Re Proposed Expansion of FLEO House, for temporary
Accommodation P10, 16 + JH Yac Ref A/110/19/HH.

Further to our Recent Discussions Please find a
preliminary Revision to Drawings 18/4553/1 & 6.

18/4553/6

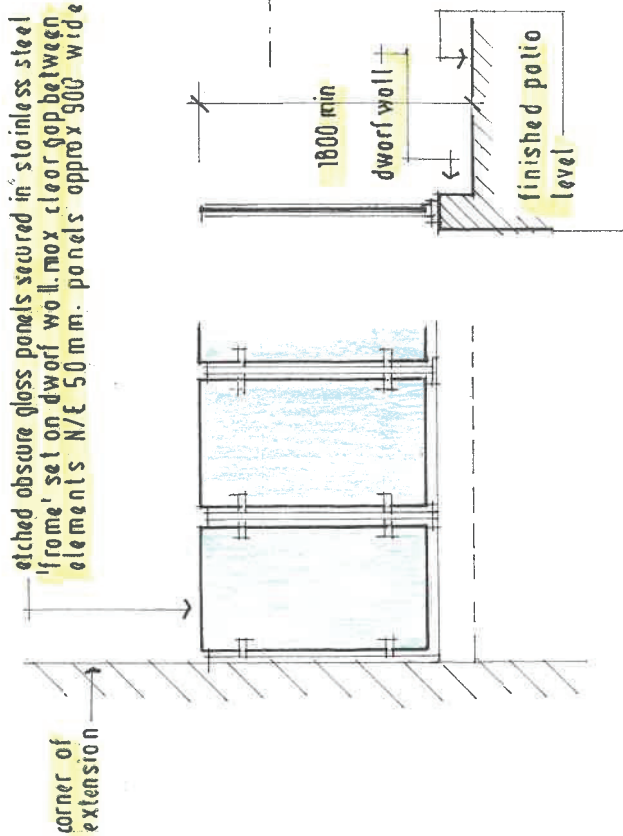
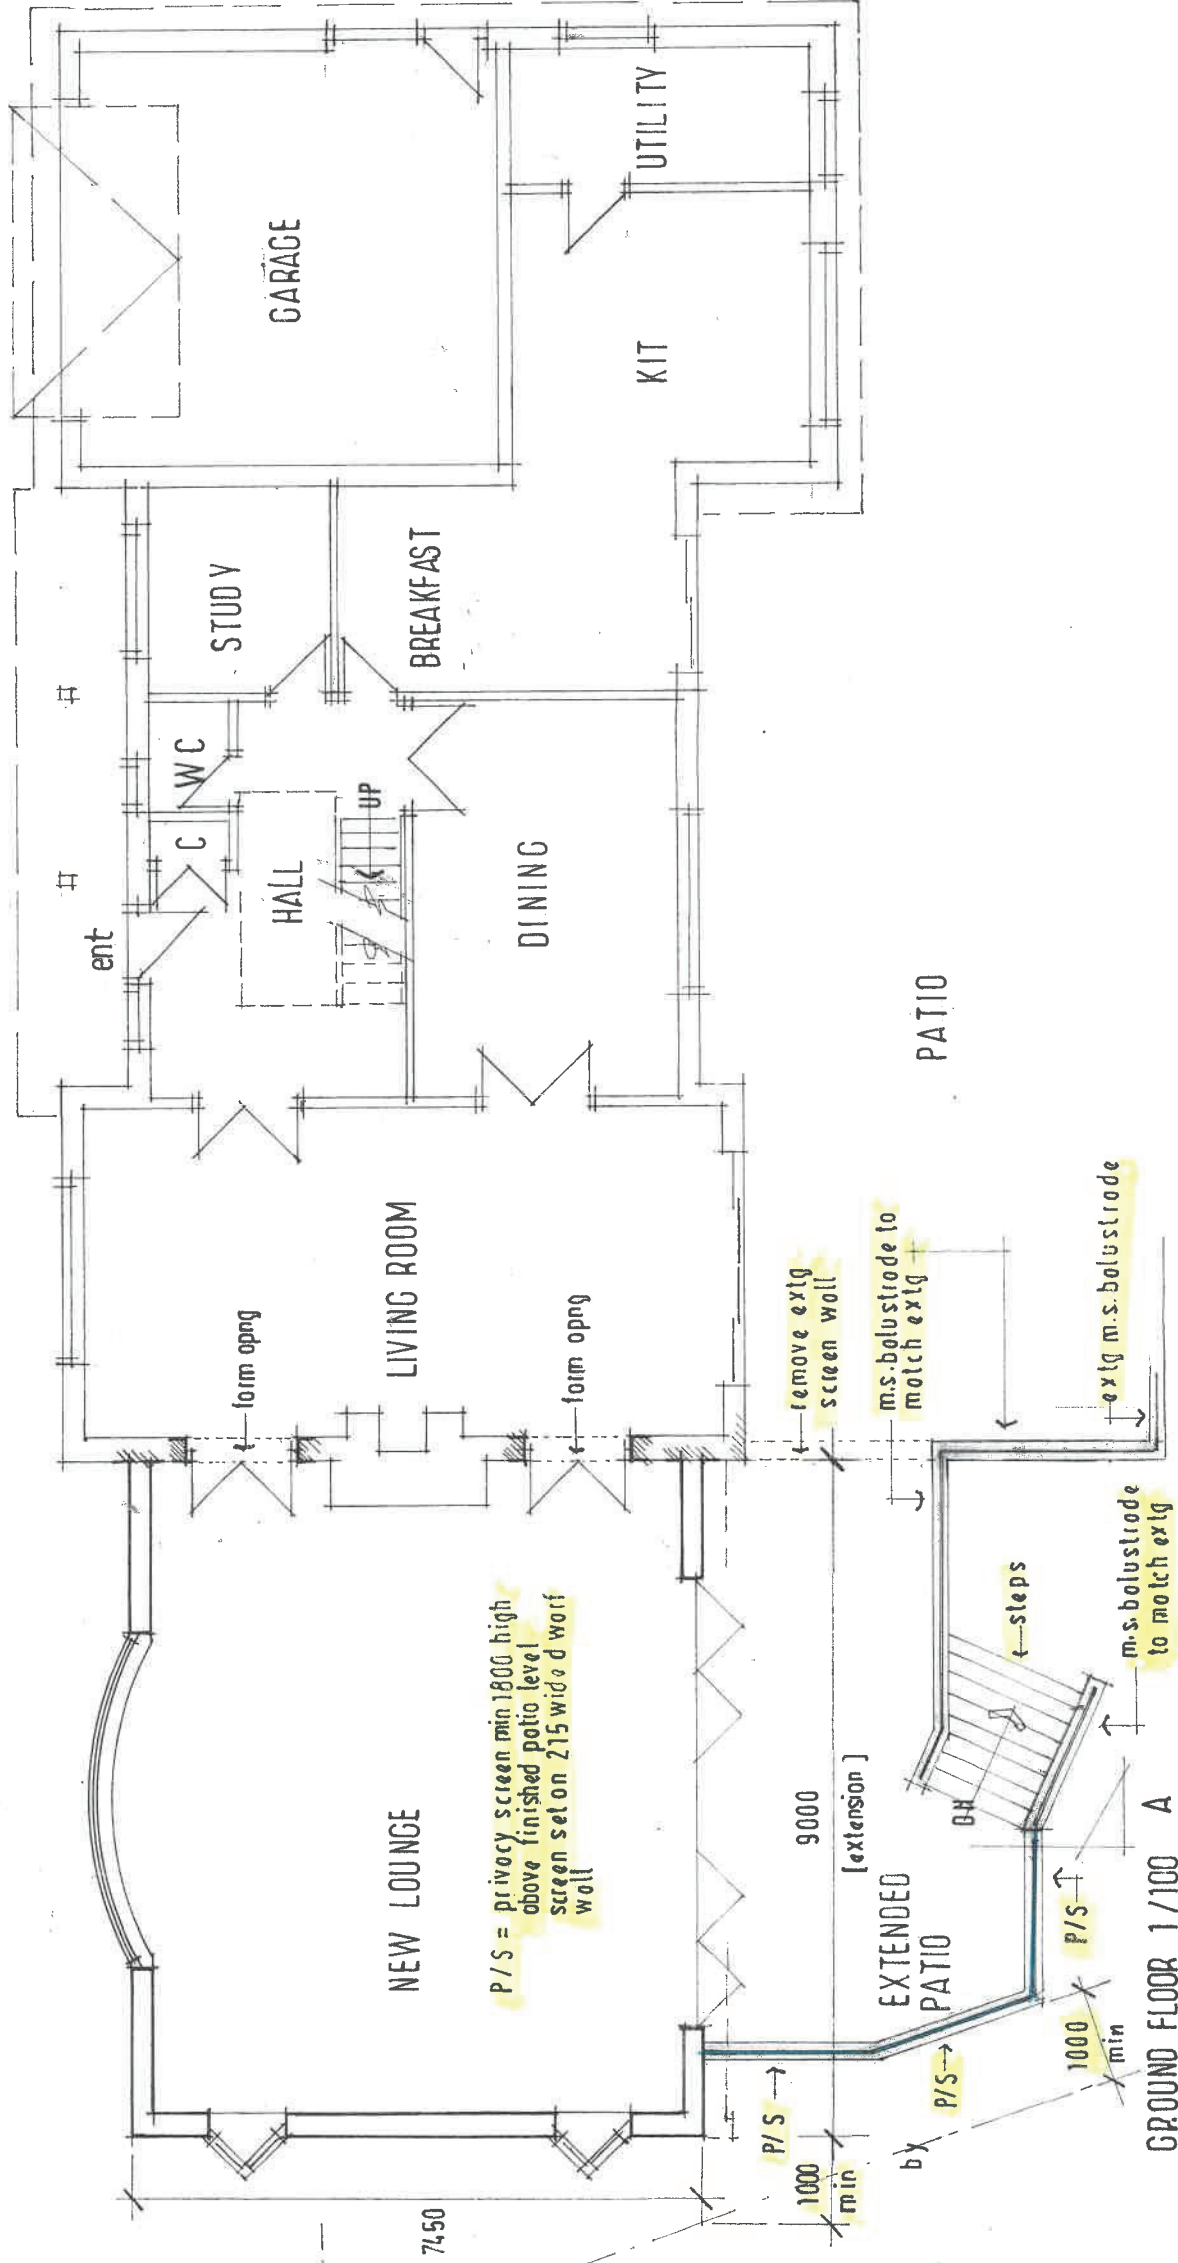
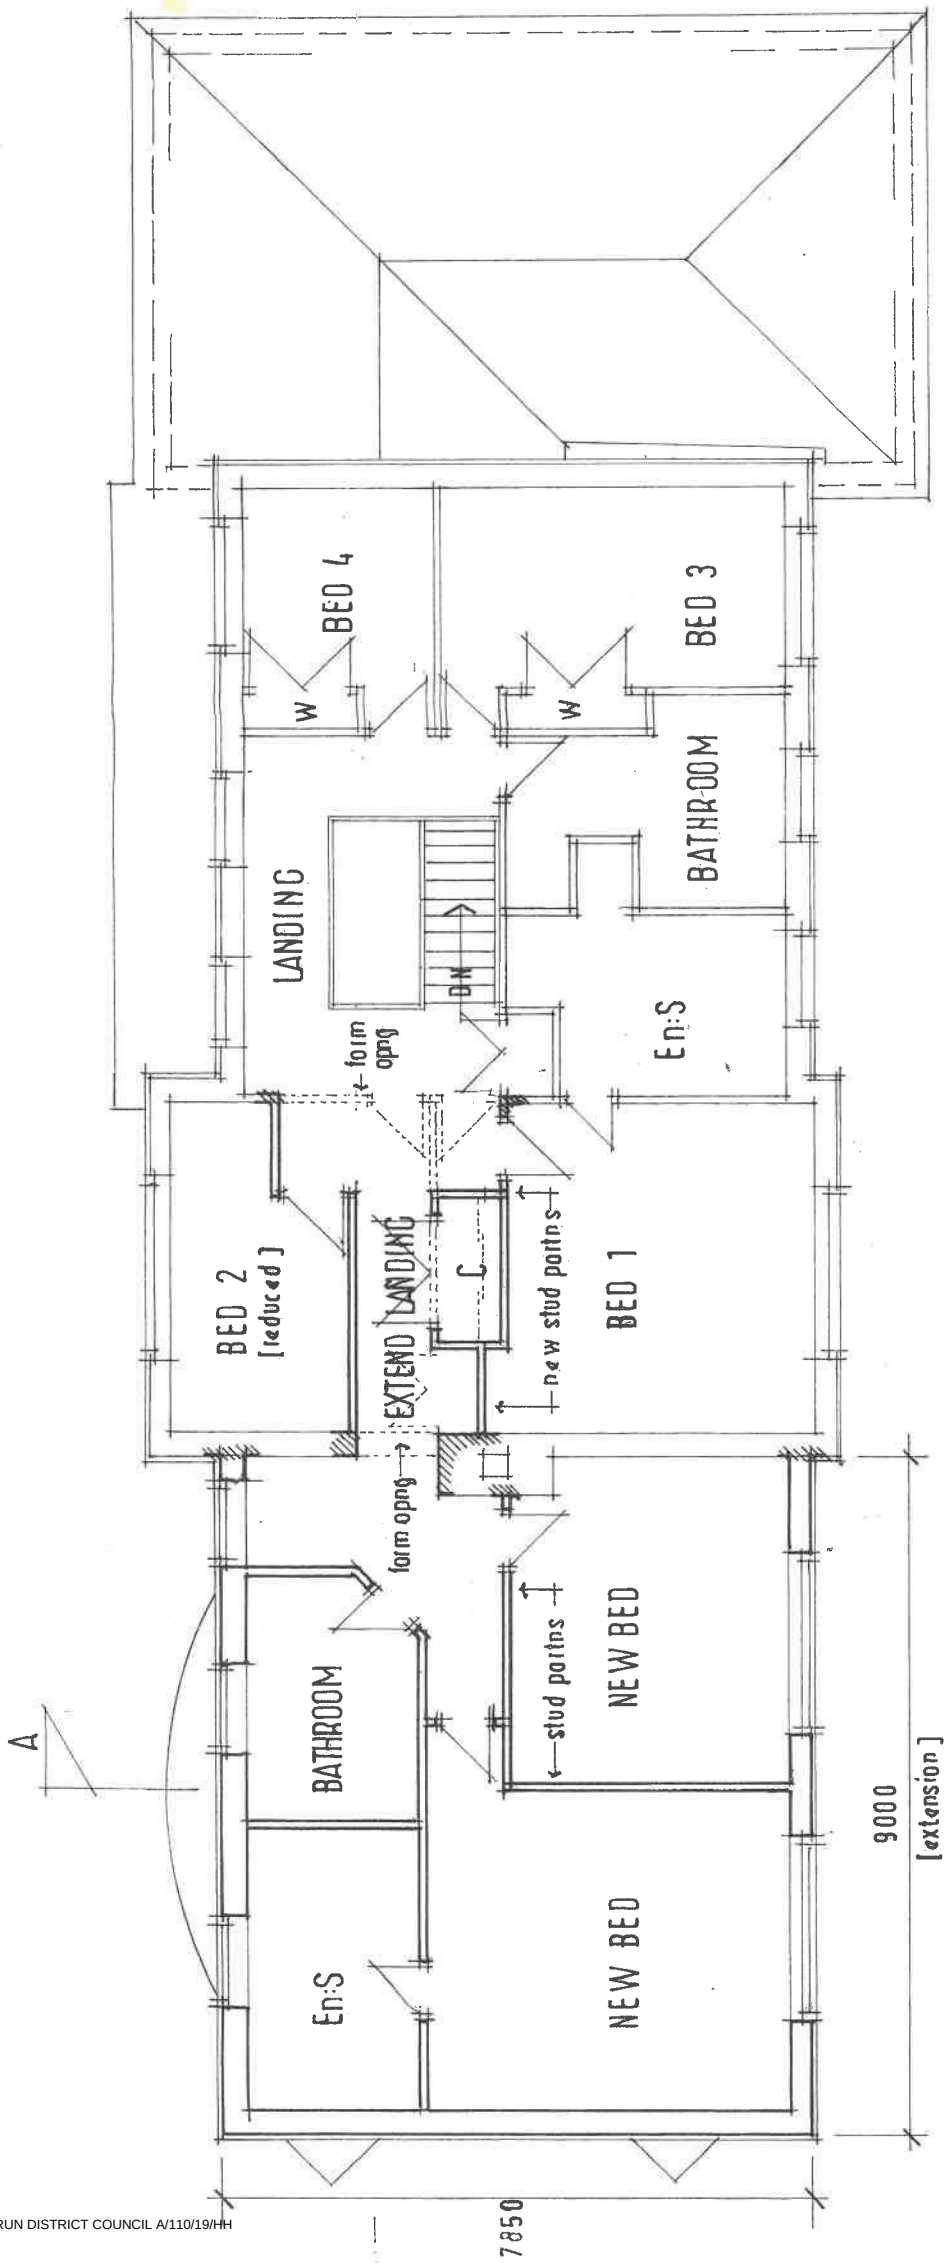
18/4553/- Indicates the proposed Privacy Screen
to the West & Part South of the Extended P10.

Date: APRIL 2019 18/4553/1

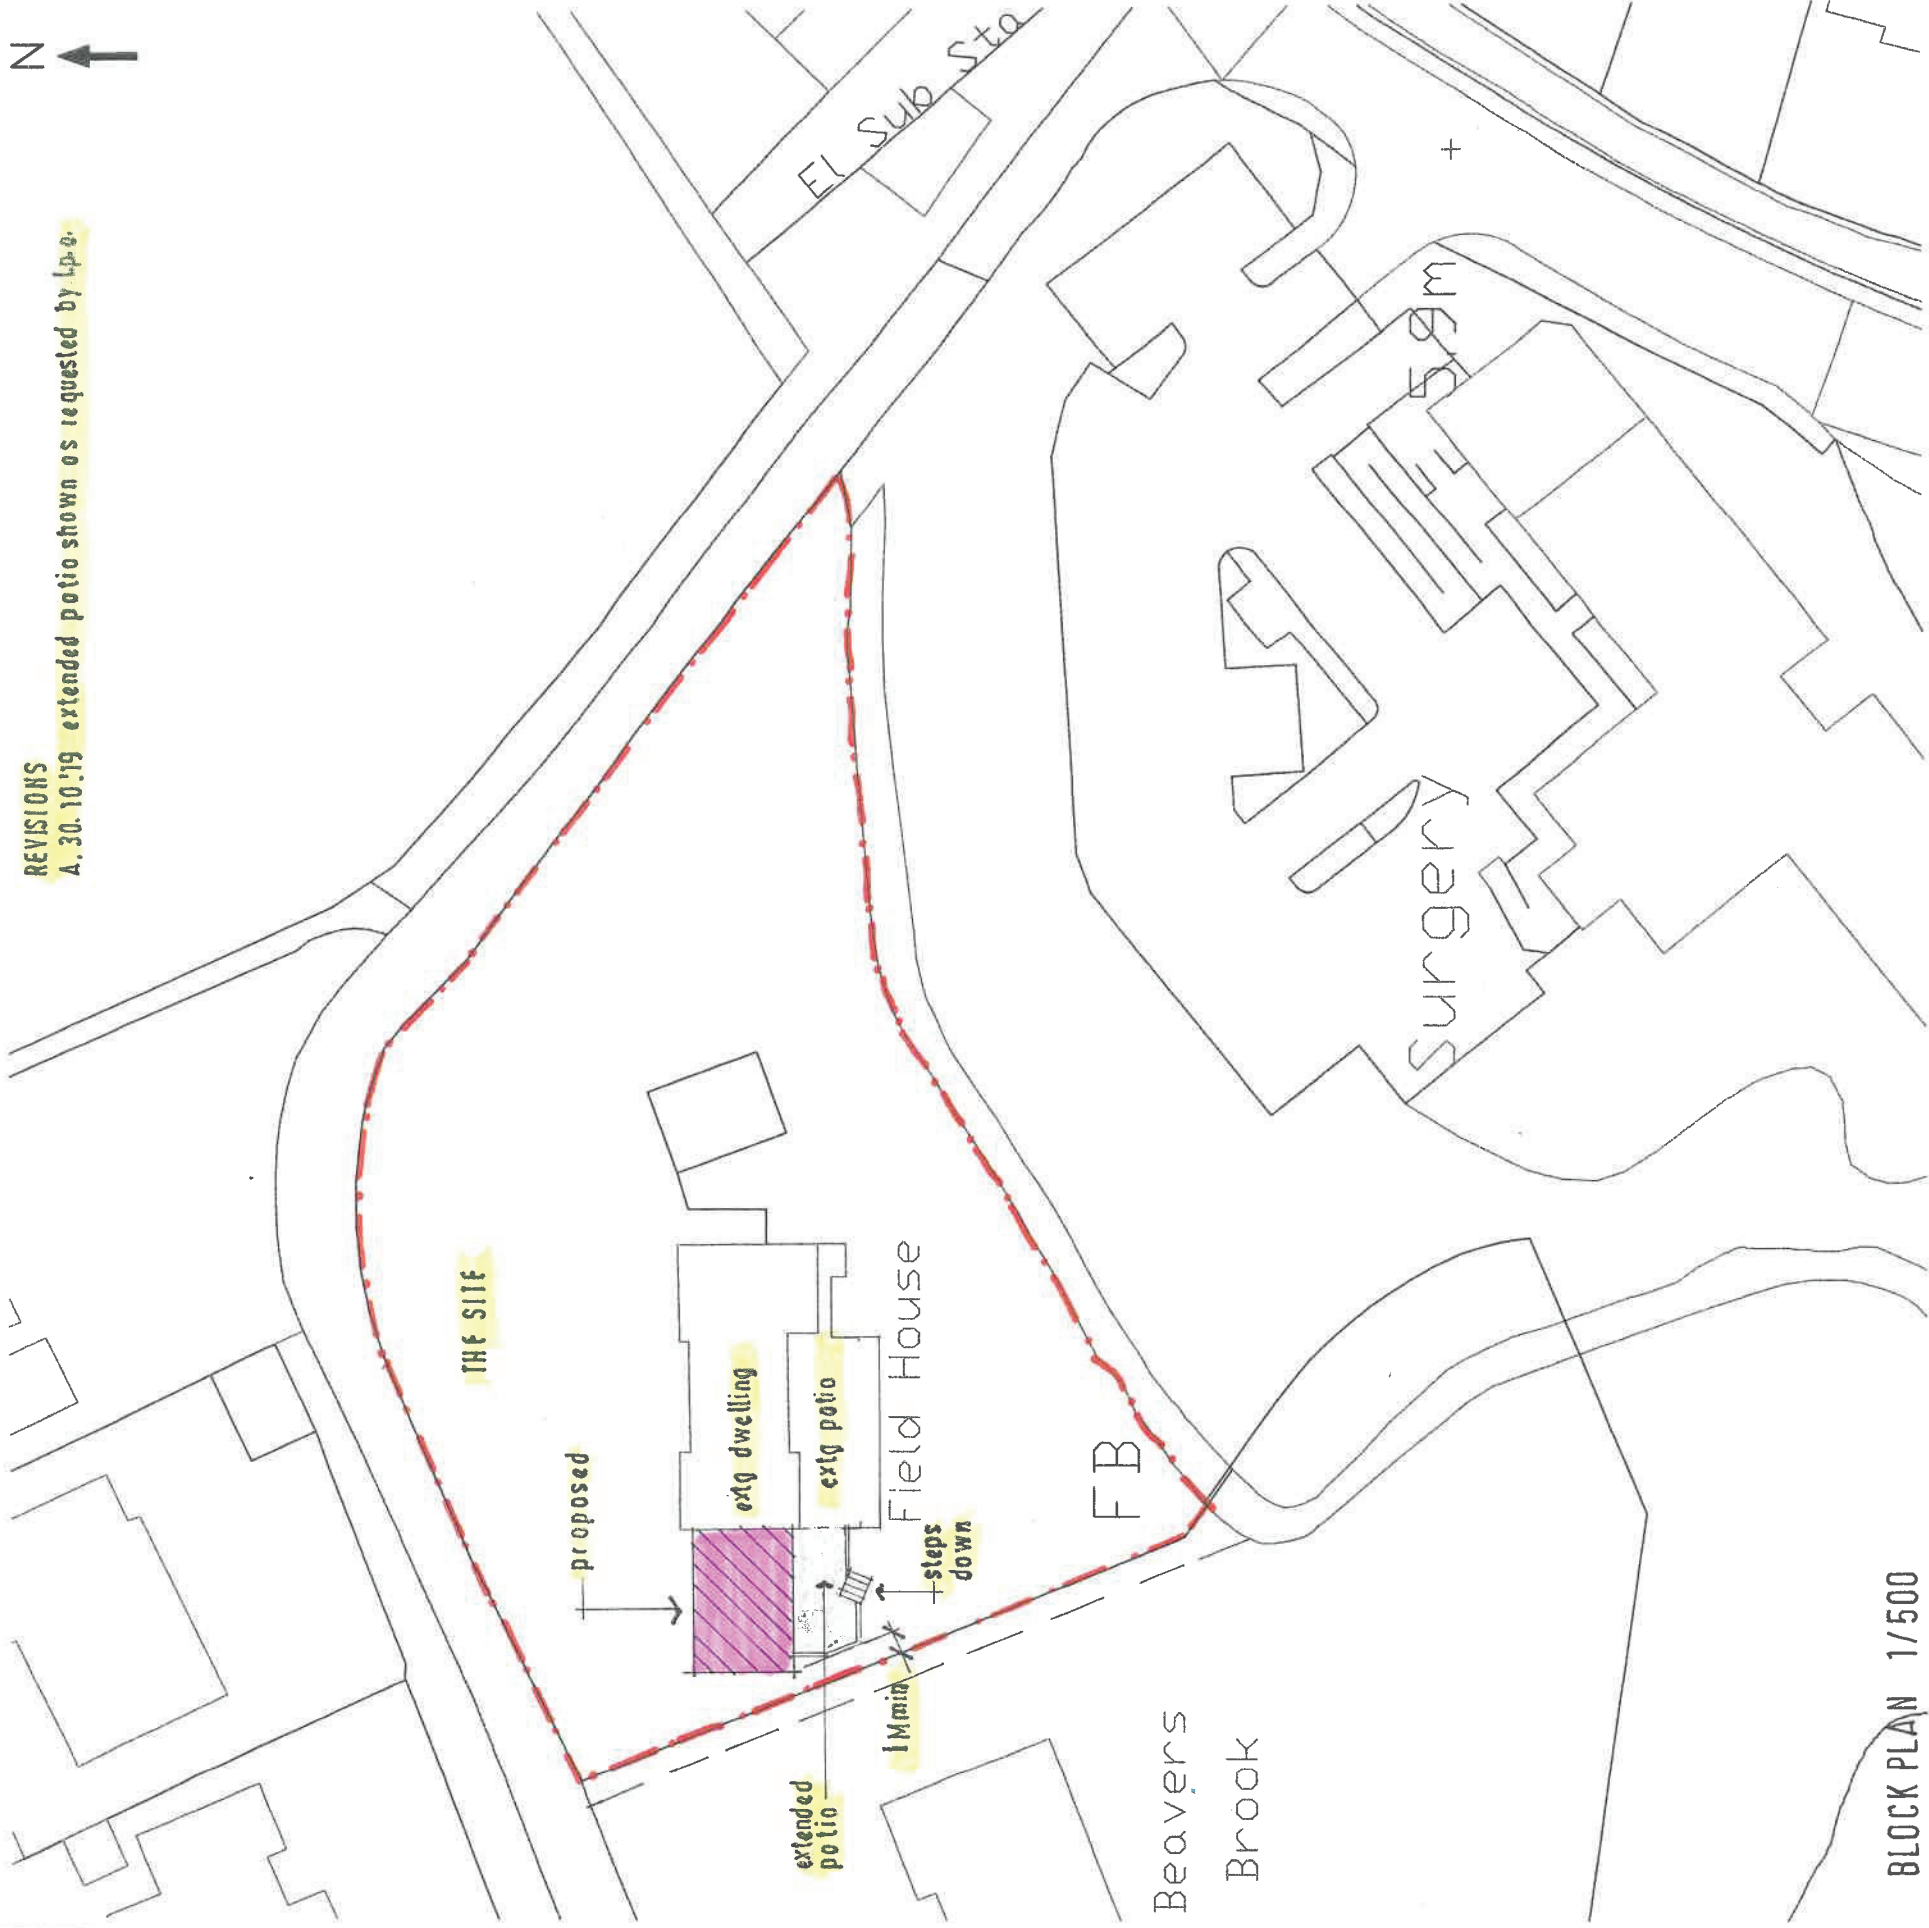
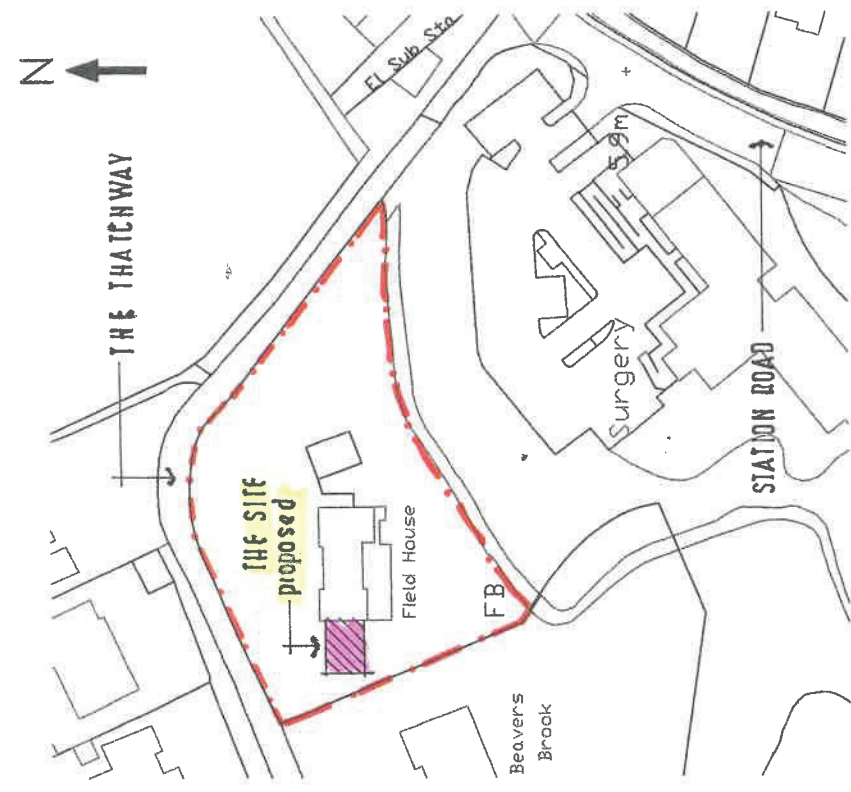
18/4553/1 - Shows the extended P10 area to
the Reception
